Our ref: DOC21/1018764 and DOC21/992934  
Senders ref: SSD 9249 Mod 6 and SSD 9835 Mod 7

**Subject:** Exhibition – Football Stadium Concept Proposal – Modification 6 – Inclusion of Precinct Village and Carpark Envelope (SSD 9249 Mod 6) and Sydney Football Stadium Stage 2 (design and construction) – Modification 7 – Precinct Village and Carpark (SSD 9835 Mod 7)

**Attachment 1:** Football Stadium Concept Proposal – Modification 6 – Inclusion of Precinct Village and Carpark Envelope (SSD 9249 Mod 6) and Sydney Football Stadium Stage 2 (design and construction) – Modification 7 – Precinct Village and Carpark (SSD 9835 Mod 7)

Building Envelope & Footprint - Undercroft / Ground

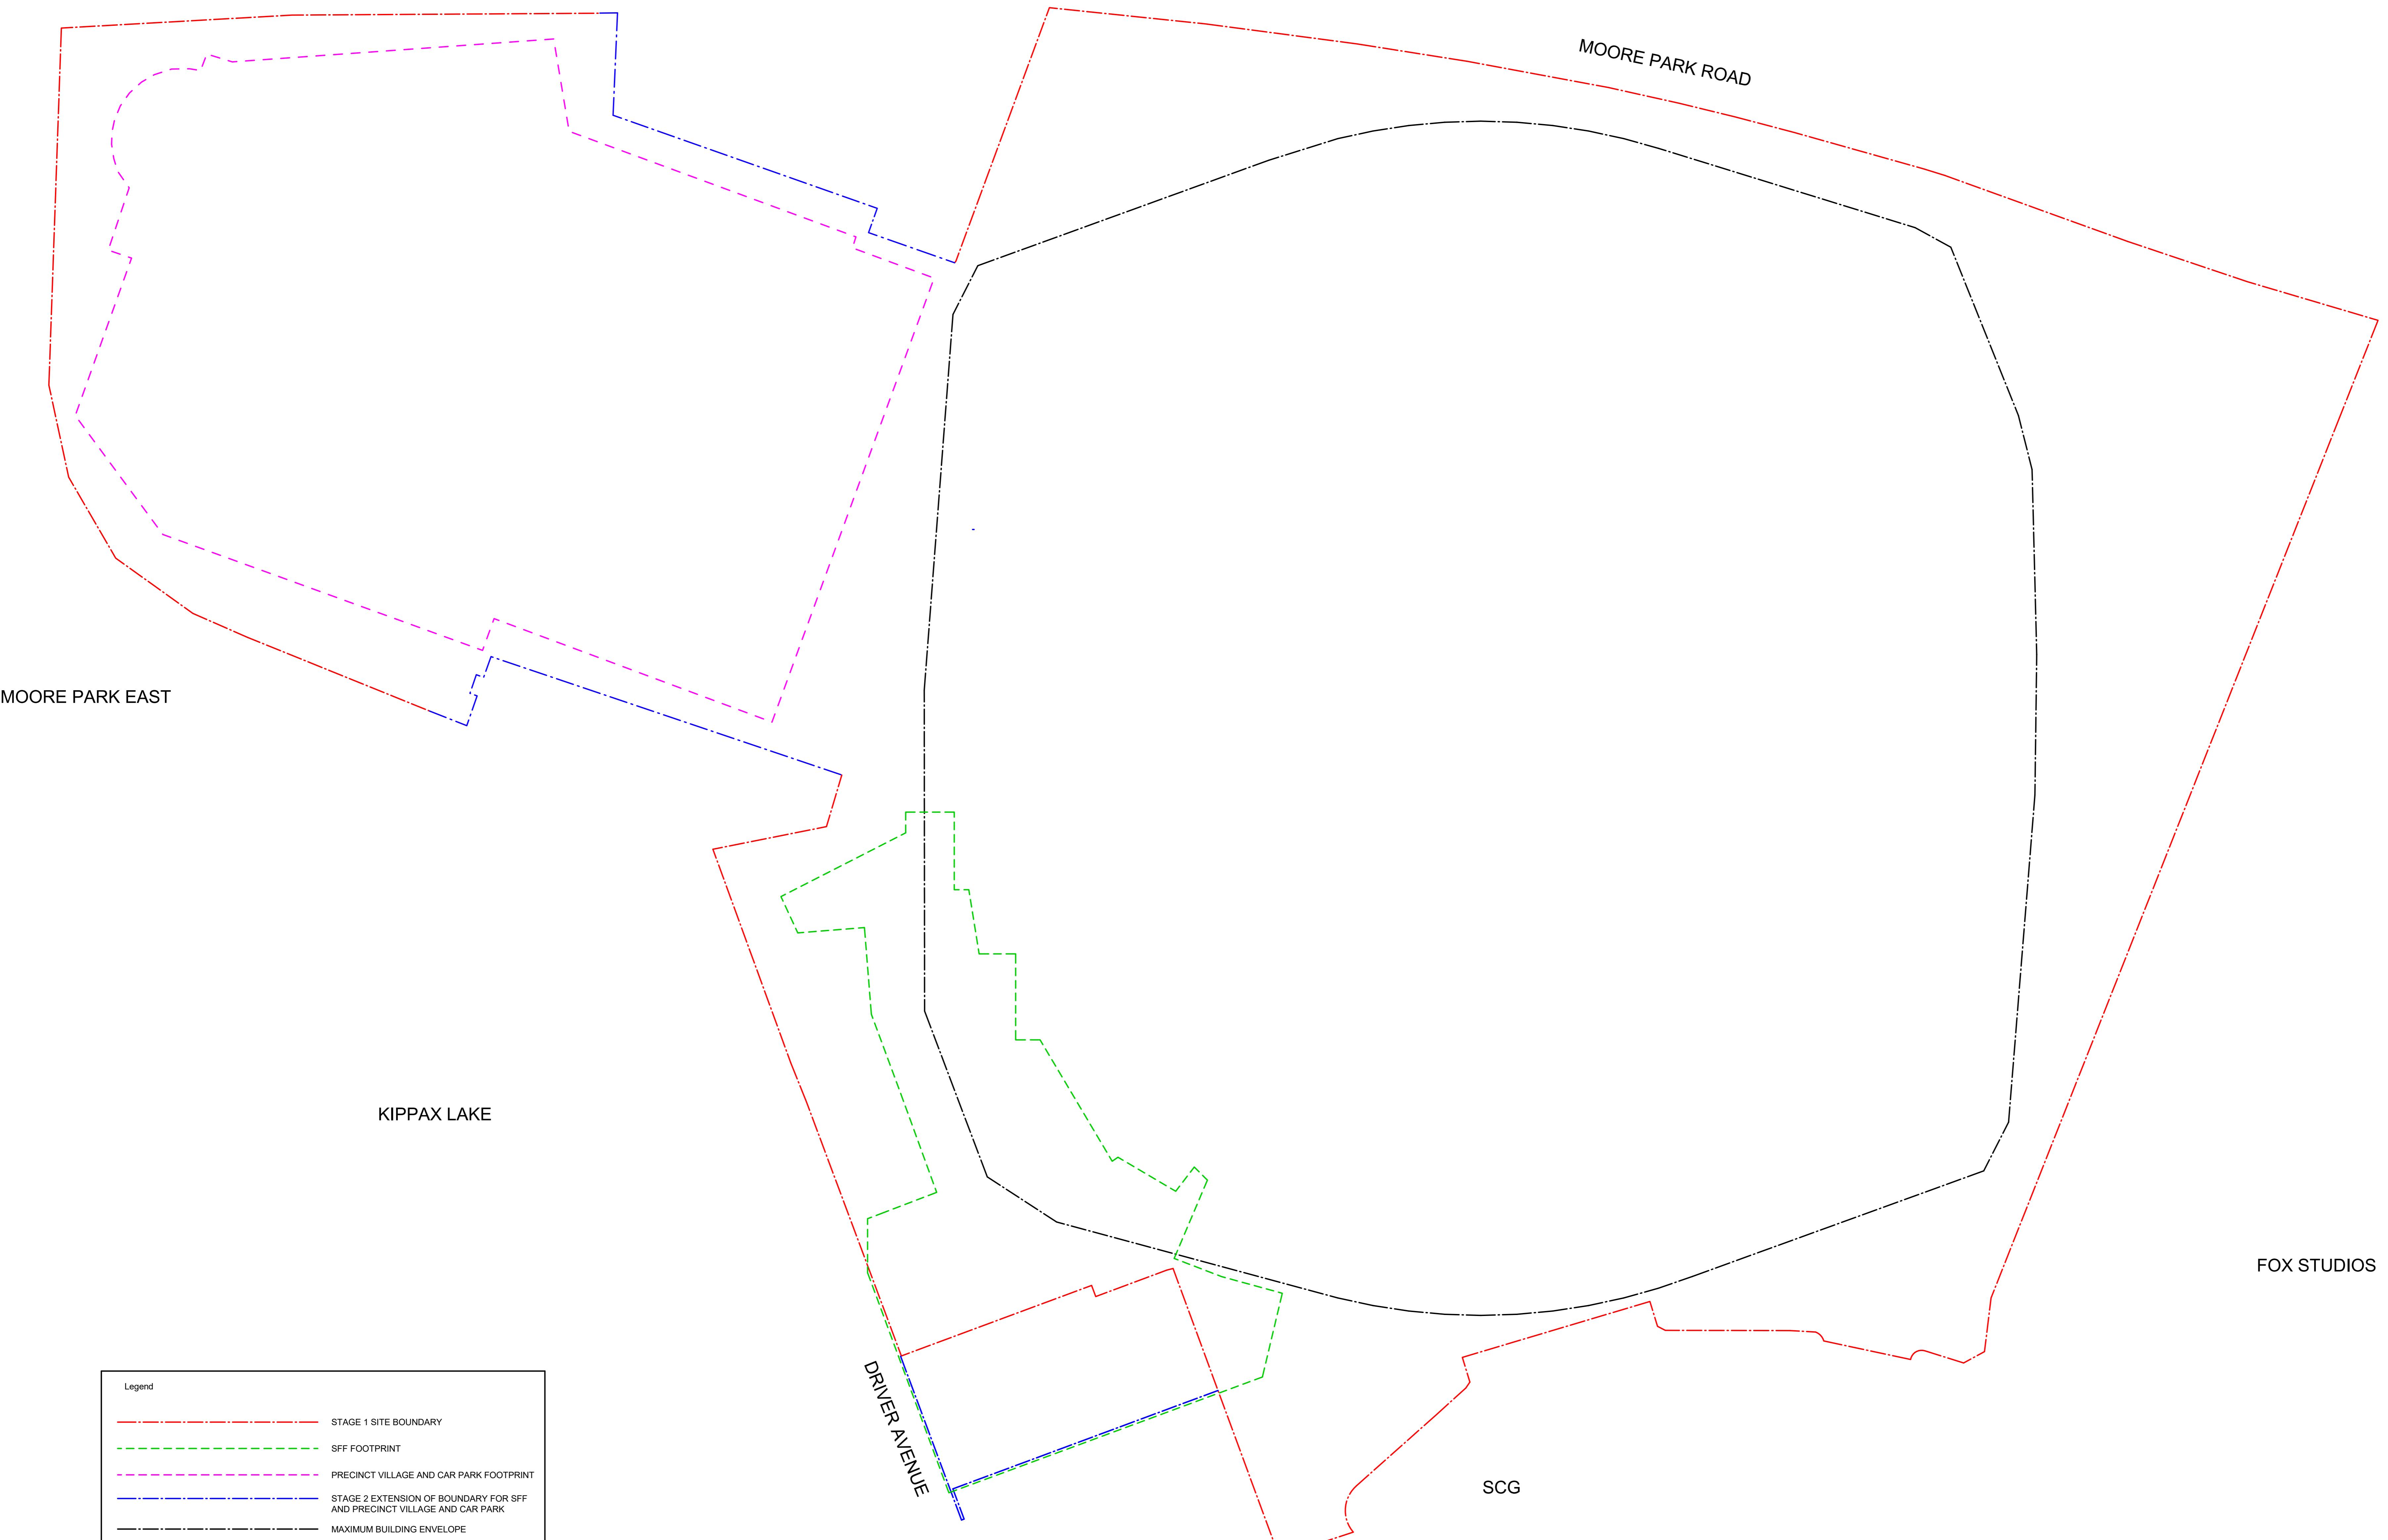
The flood model does not appear to be consistent with the architectural drawings. The drawings show a set of stairs connecting to Moore Park Road, adjacent to the proposed north-south road. These stairs would significantly impact flood behaviour and notably, this could exacerbate some of the concerns below.
